Subject: FW: BR/57/20/DOC, Drainage Engineers comments

From: Sarah Burrow <Sarah.Burrow@arun.gov.uk>
Sent: 22 May 2020 17:17
To: Maria Tomalova <Maria.Tomalova@arun.gov.uk>
Subject: RE: Planning Consultation on BR/57/20/DOC

Engineers Comments Regarding Surface Water Drainage

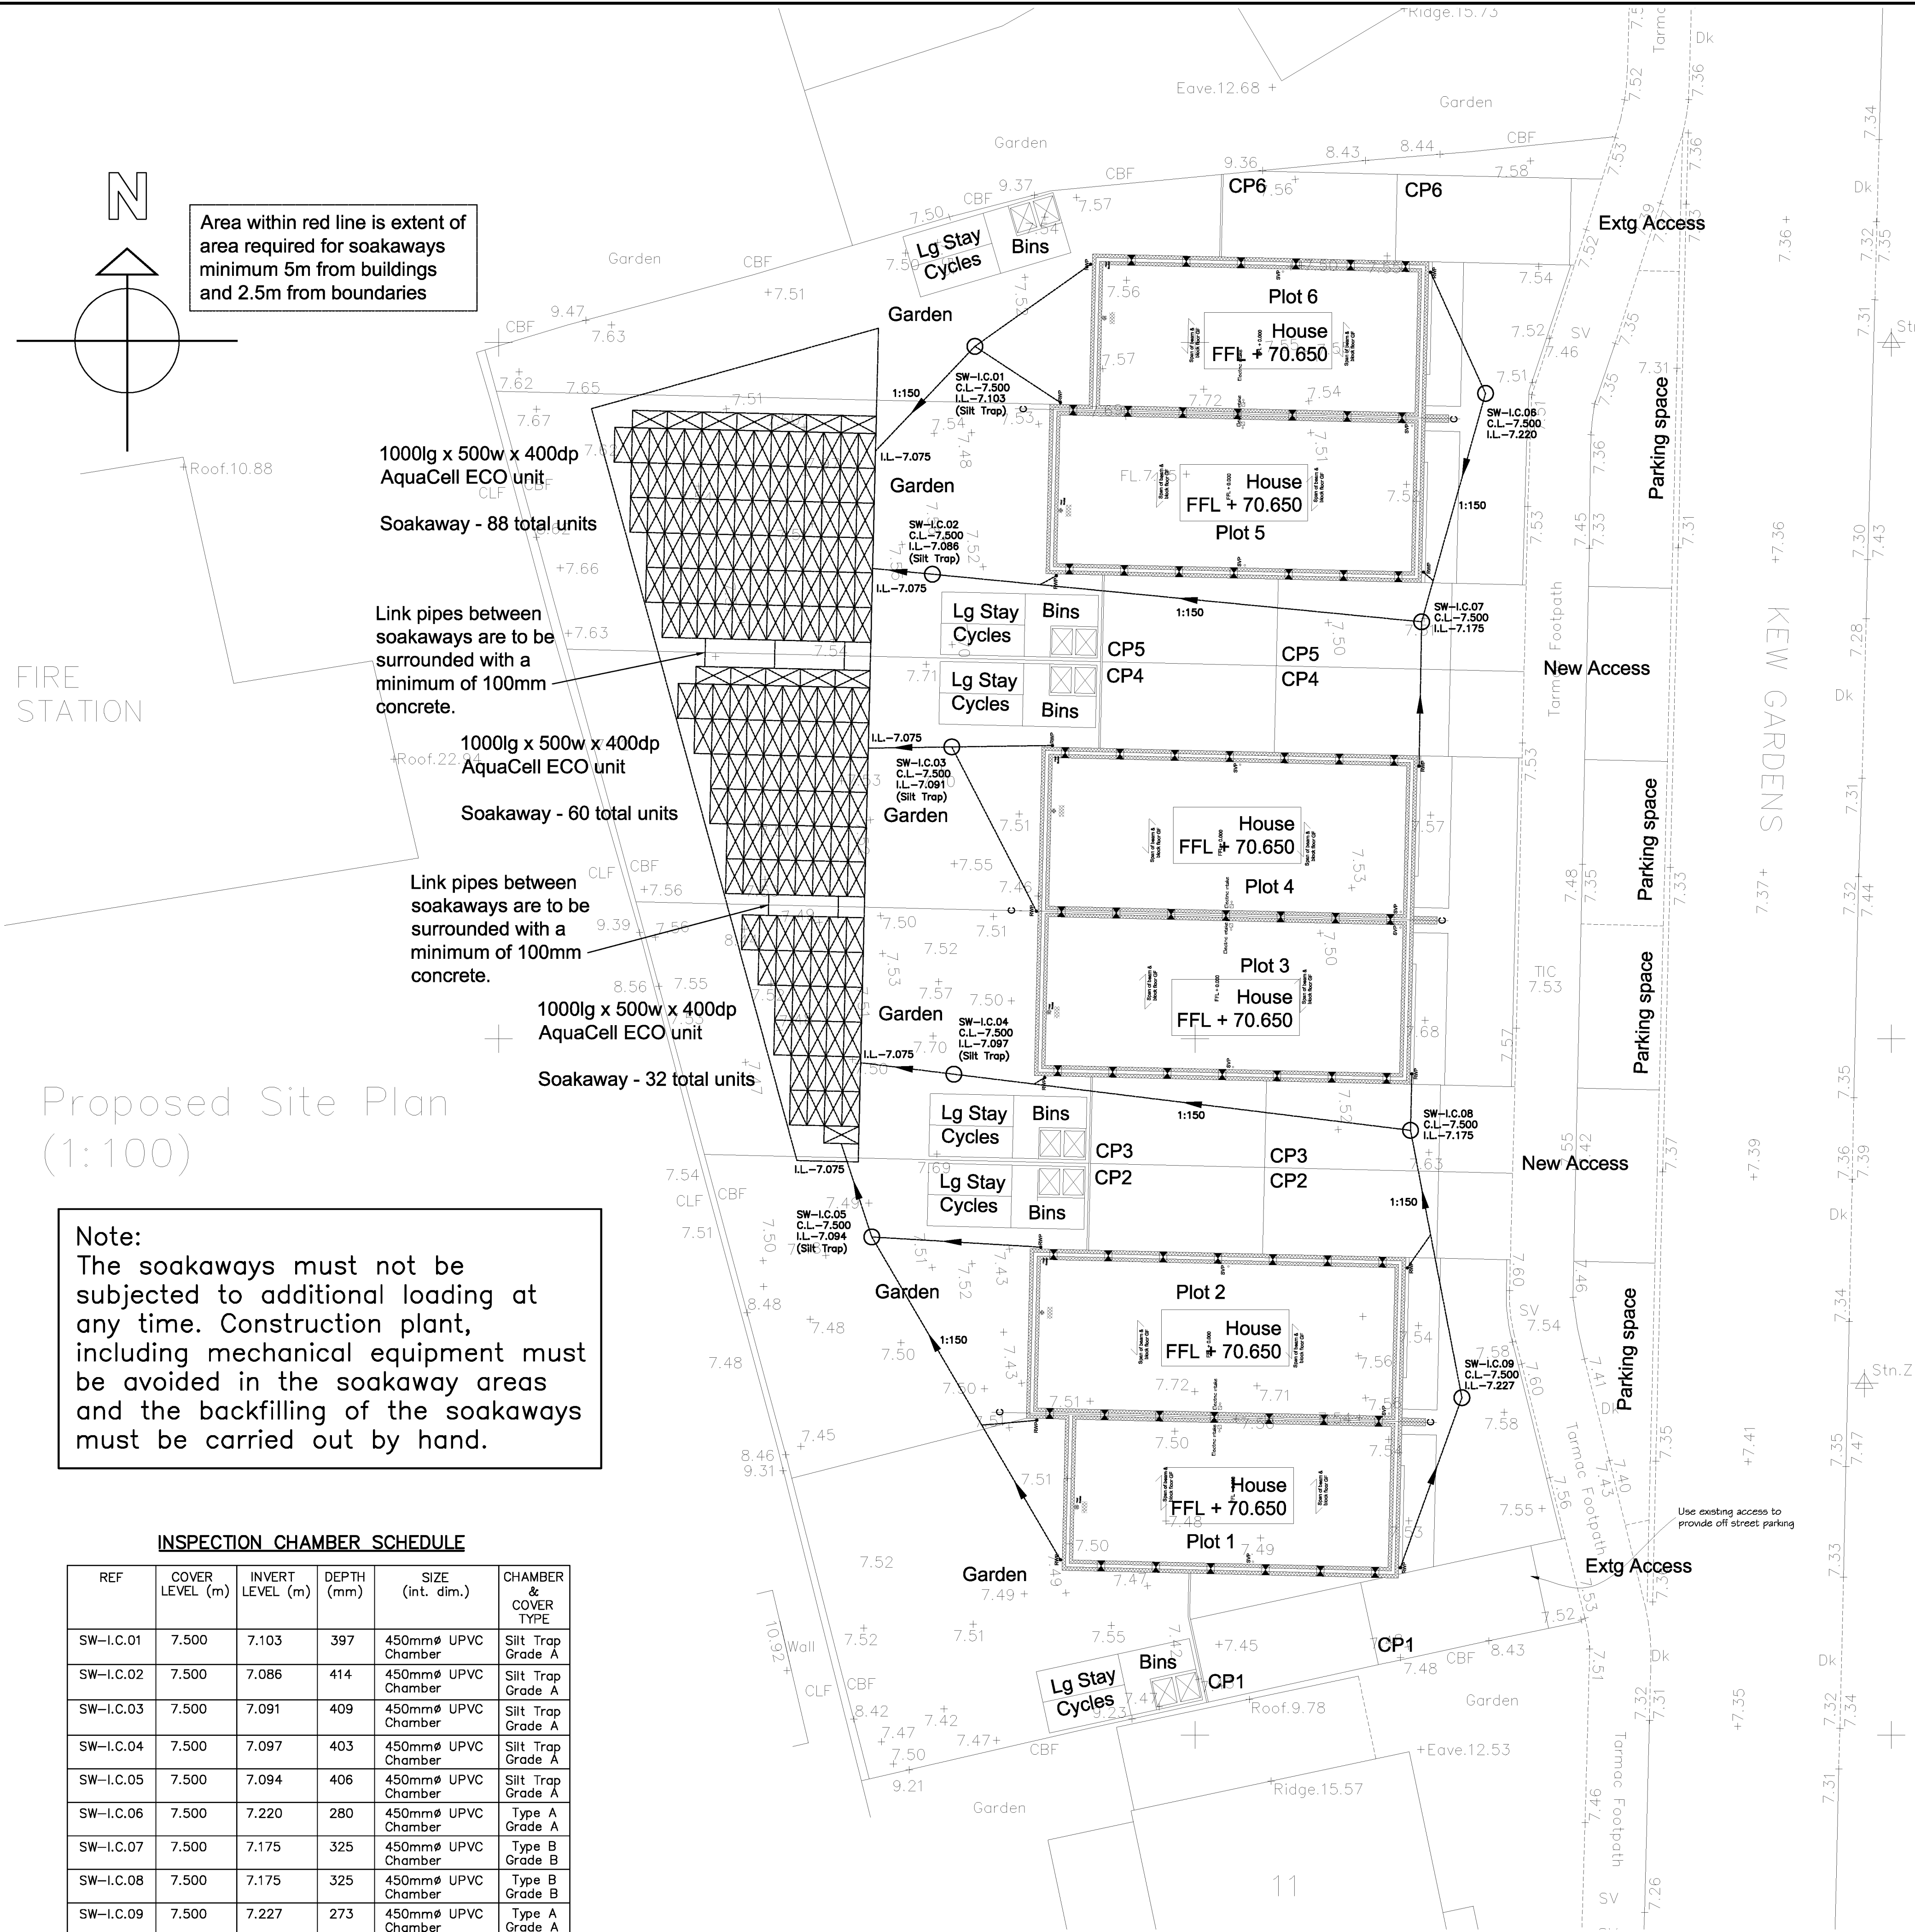
4. Please label soakaways with their invert levels, cover levels and cover types (not necessary if construction detail is kept on same drawing, in which case "see detail for levels" – only if moved to a separate construction details sheet, see below). This is still unclear, the existing topography shows ground level to be at 7.5 for most of the soakaway areas which will only provide 300mm of cover rather than the 400mm specified. Luckily this is acceptable with the chosen crates, however the note needs to be changed to reflect this. In addition, the levels on the site vary and yet the cover depth is uniform on the detail. It is assumed that the three soakaways will be set at the same base level 6.8. If this is the case, using the detail is sufficient, however the cover depth should be changed to reflect that it varies for the different soakaways. IE. Min 300mm and Min 700mm to the base of the soakaway. *We have provided the details of the soakaways as standard details. Generally the existing/proposed ground levels to the rear gardens is uniform at around 7.5m Yes it is accepted that the ground might vary 100mm across the site but the detail shows the worst case scenario of having a minimum cover of 300mm and the soakaways being all set at the same base level of 6.8m. I don't see why we have to specifically change the detail to show exact ground levels the detail is standard and the contractor will work with this and then adapt ground levels and covers to suit. It seems you are expecting the details to be spot on with levels but in reality there will be fluctuations of around 100mm on site. The detail provides the required information for the soakaways to be constructed to regulations and this will be adapted to ground conditions/levels on site which will be inspected by the building inspector and warranty provided. You do not need to show the exact ground levels (although that of course would be preferable, and in keeping with my first consultation) simply adding the word 'min' to the dimensions in question on the detail covers off this point so that it is understood that these will vary. I have already compromised on this by not standing firm on all levels being included on the drainage layout. If the construction detail is to be relied upon, then it needs to reflect all three soakaways. This is a simple adjustment and I have no idea why it is being argued.*

TYPICAL SECTION
STORM WATER SOAKAWAY DETAIL
1:20

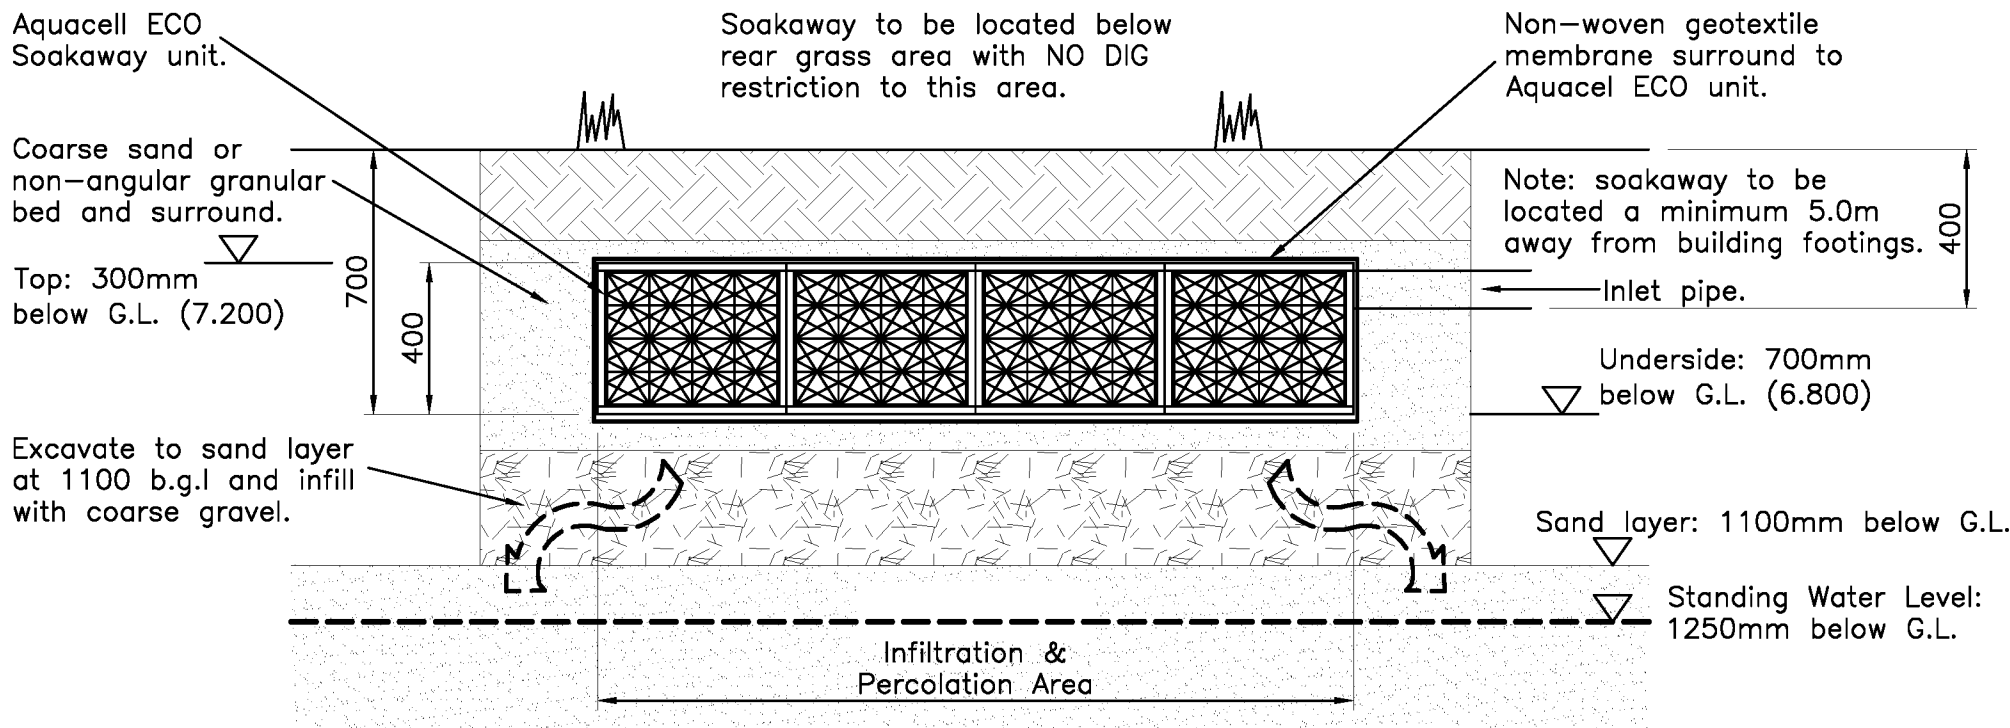
2. The link pipes between the soakaways need to be surrounded in concrete and it is strongly advised that the applicant includes an inspection chamber on at least one of these pipes (please label this manhole/inspection chamber with invert and cover levels and cover type). Concrete surround specified, no inspection chamber. *In relation to point 2. My engineer says that there is no requirement or need to have inspection chambers on the link pipes. The link pipes are very short lengths and are encased in concrete therefore provide a sealed link between soakaways. The link pipes are short in length therefore putting a manhole on them will mean putting it on the fence line which is not practical. The manhole would then be push further to one side of the fence very close to the soakaway. This is just not practical or needed.* Fine. The inclusion was suggested by the Principle Drainage Engineer but was always a suggestion, the argument against is sound.
